**WEST SUSSEX COUNTY COUNCIL  
INFRASTRUCTURE CONSULTATION**

**SUBJECT: AB/13/09/ - Proposed 3 bedroom dwelling (resubmission of planning application (AB/68/06))**

**Land Adjacent to, 1, Anne Howard Gardens, Arudel, West Sussex**

BLOCK PLAN
SCALE 1:500

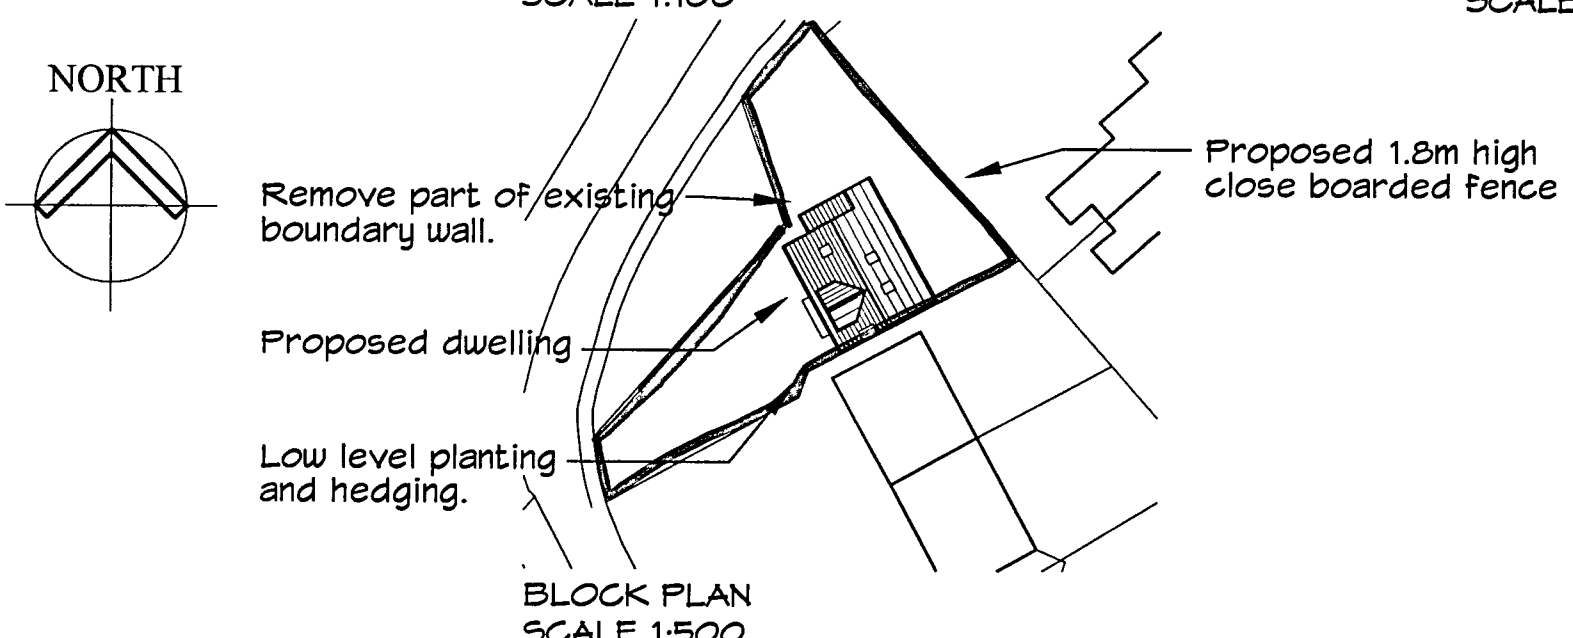
The proposal is for a 3 bedroom dwelling with access onto London Road via Anne Howard Gardens. Anne Howard Gardens is a private road not maintained by WSCC. The application form states there is to be no off-street vehicular parking at the new dwelling. It is unclear as to whether the applicant intends to use private carriageway for vehicular parking. Even though this proposed property is in a relatively sustainable location it is likely that this development will call for some vehicular parking. The LPA should consider this point prior to any approval of planning permission. The supporting application form states that no secure and covered cycle parking is being proposed in association with the new dwelling. PPG13 identifies that cycling has the potential to substitute for short car trips, particularly those under 5km, and to from part of a longer journey by public transport. Therefore Policy DEV5 of the West Sussex Structure Plan requires new development to provide convenient, attractive and safe cycle storage. WSCC standards would require 1 cycle space to be provided for each bedroom of the new dwelling. The applicant should identify suitable cycle storage to satisfy policy DEV5.

From an inspection of the plans alone, there is no apparent visibility issue at the point of access onto London Road and Anne Howard Gardens. In principle, it is unlikely that there would be any issues with this proposal. A number of dwellings are already served from

The dwelling, hereby approved, shall not be occupied until the car parking has been constructed in accordance with the approved site plan. This space shall thereafter be retained at all times for its designated use.

No dwelling, hereby approved, shall be occupied until covered secure cycle parking spaces have been provided in accordance with a detailed construction plan to be submitted to and approved by the planning authority.
